Reference No:	2024/70/91088/E
Site Address:	land at, Westfield Farm, Barnsley Road, Flockton, Huddersfield, WF4 4DW
Description:	Variation of condition 2 (plans) on previous permission 2023/90171 for demolition and re-building of existing farmhouse with extensions and the erection of one dwelling (amended house type)
Recommending Officer:	Nicole Helliwell

DECISION – APPROVE VARIATION OF CONDITION 2

Officer Report

DRAWING TITLE
UNIT 3 FARM HOUSE - GA DRAWING

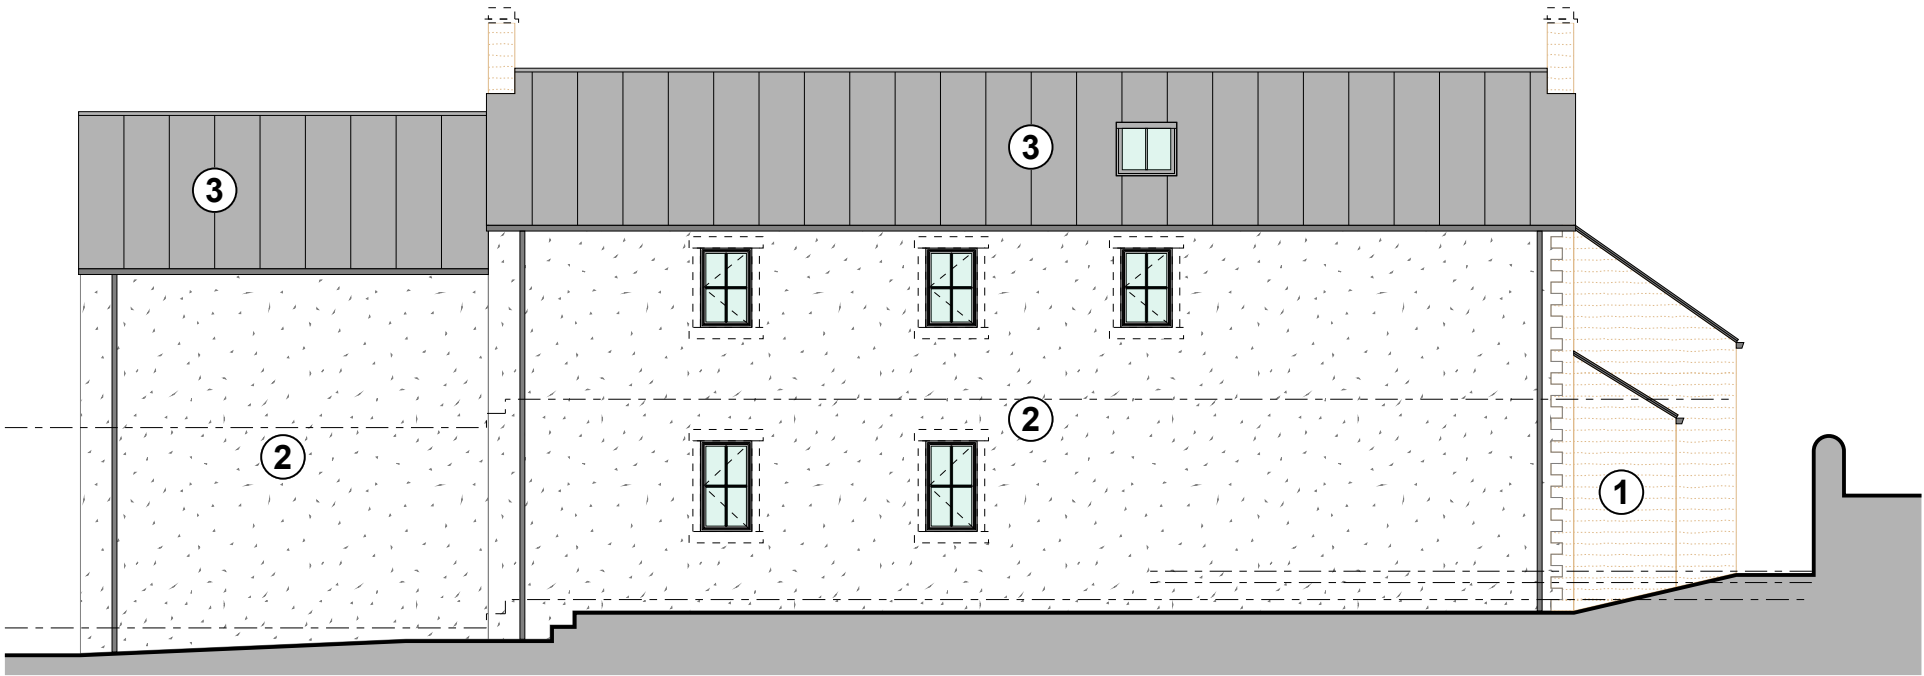
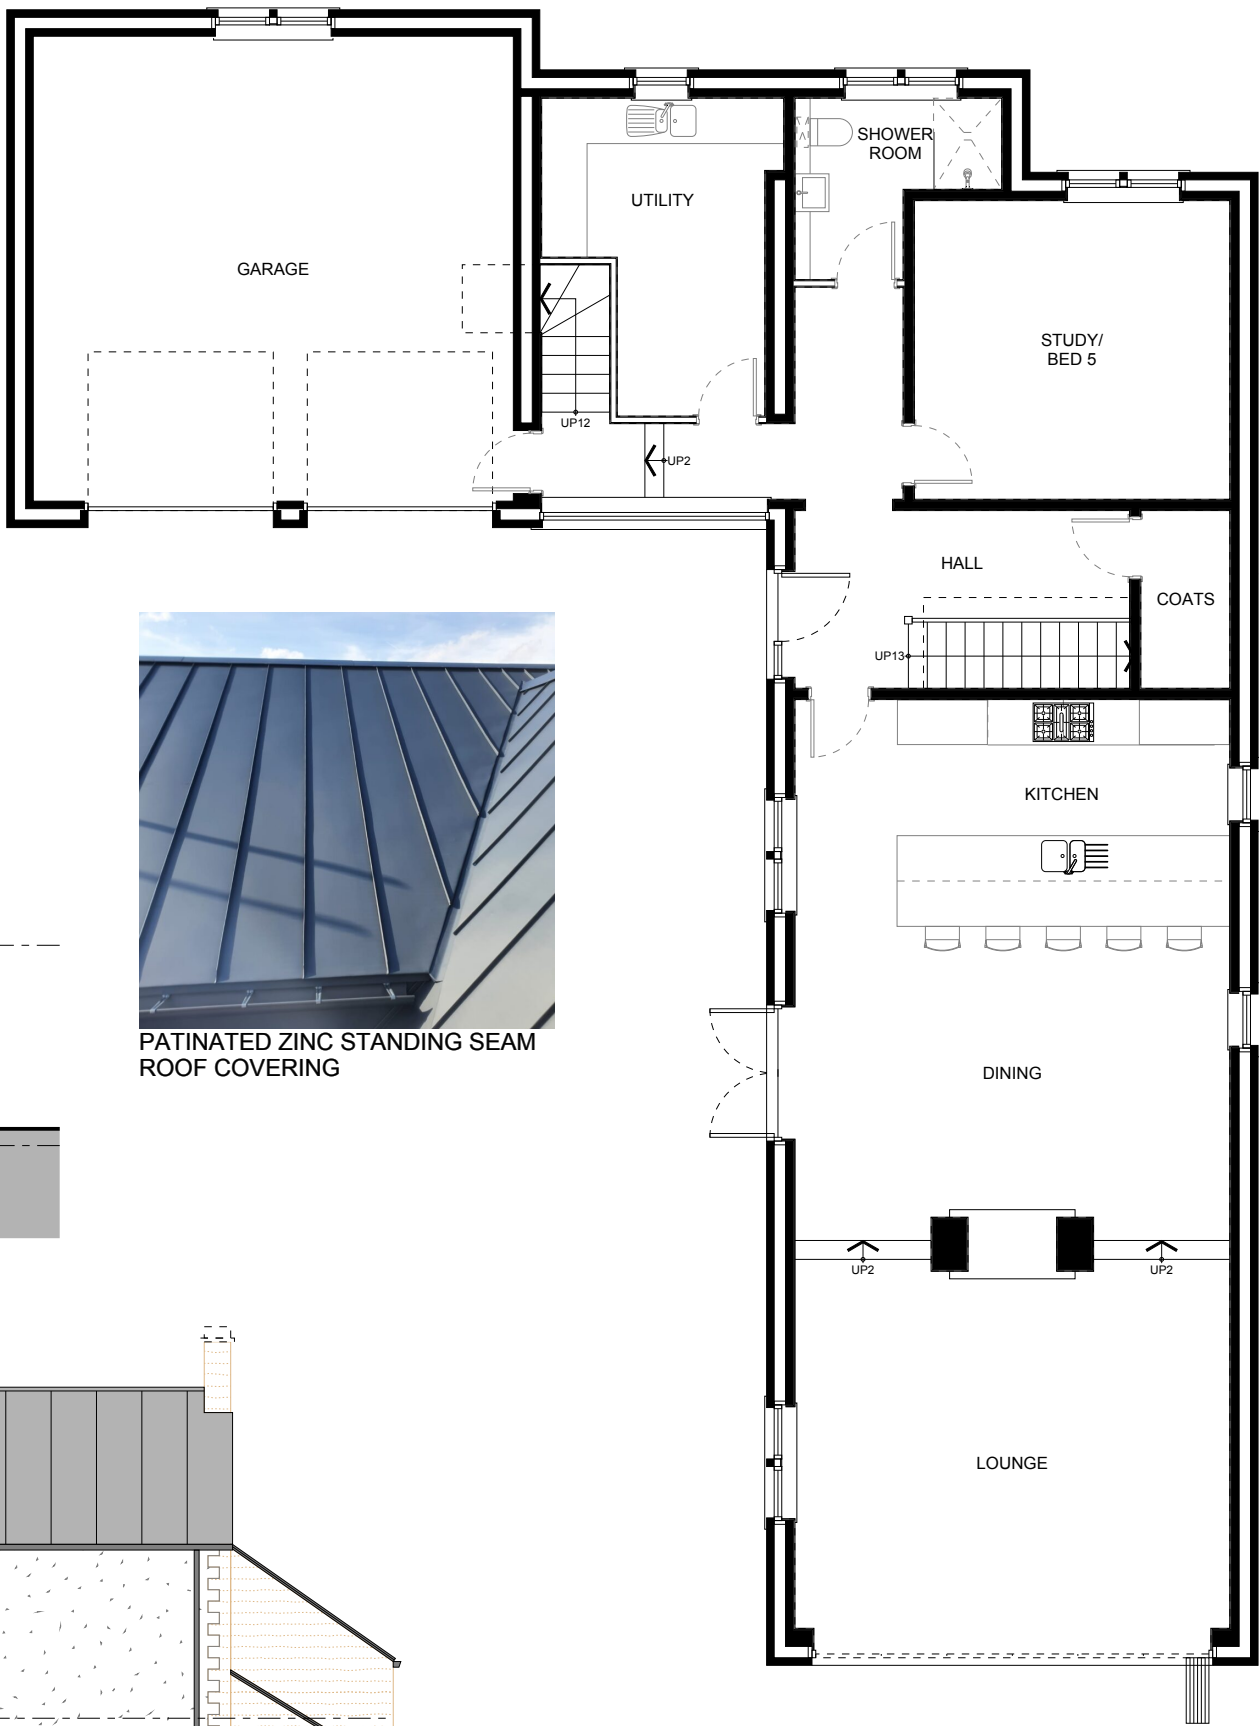
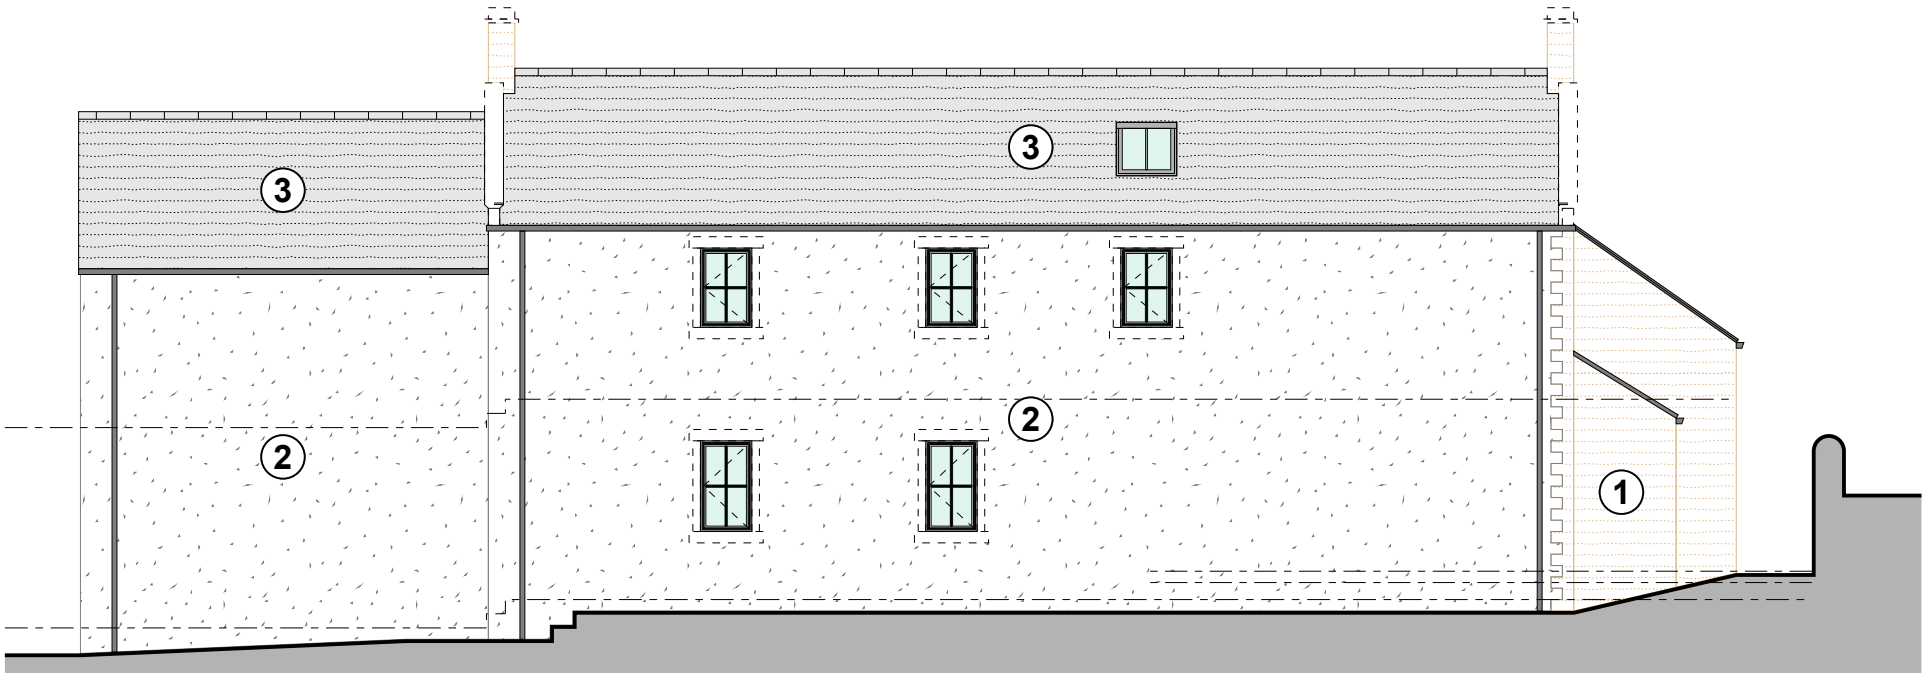
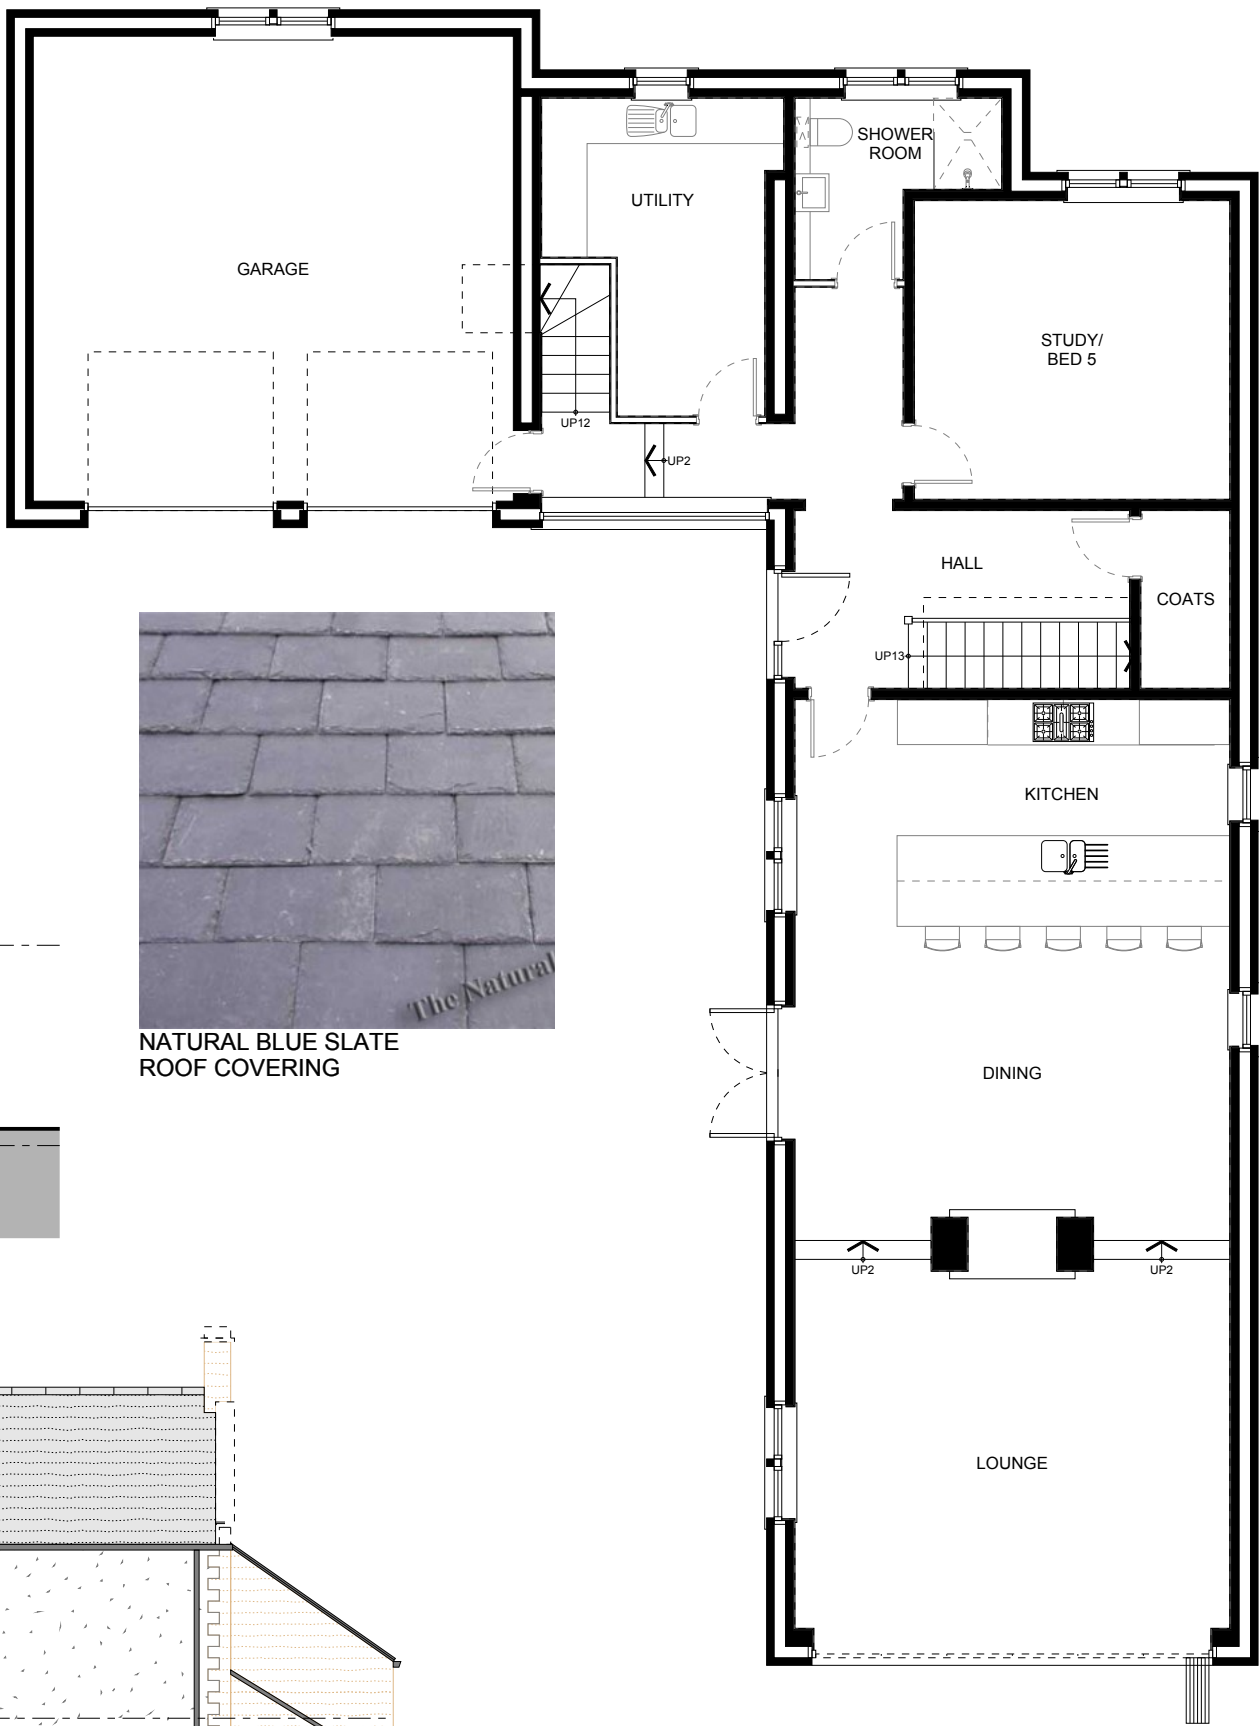
This Section 73 application seeks to vary the approved plans for Unit 3 due to changes in materials and design. The proposed alterations are as follows:

- Alterations to the size and design of fenestration within the north, west and south facing elevations

- New first floor window installed within the east facing elevation
- Application of silicone through render to part of the eastern, western and southern elevations

The proposal seeks to apply silicone through render to elements of the east, west and south facing elevations of the dwelling. Although the use of render would alter the external appearance of the property, these elements would have limited visibility from public vantage points along Barnsley Road. Furthermore, it is noted that the render forms a characteristic of the street scene. Therefore, it is considered that the alterations would not have any significant visual impact on the character and appearance of the host property and the surrounding area.

The application seeks to install a new first floor window within the eastern elevation and alter the size and design of the approved fenestration within the north, west and south facing elevations. Given that the changes would maintain the traditional appearance of the wider site, they are not considered to impact on the visual amenity of the area and would be considered acceptable from a visual amenity perspective.

It is noted that the internal layout of Unit 3 has been reconfigured since the approved scheme. Although alterations have been proposed to the fenestration on all elevations of the dwelling, the majority of the windows would serve the same rooms and are not considered to have a greater impact on the neighbouring occupants than the originally approved.

Amendments were sought during the course of the application. A request was made to change the roofing material back to natural blue slate. Revised drawings were received which were considered acceptable with regard to visual amenity.
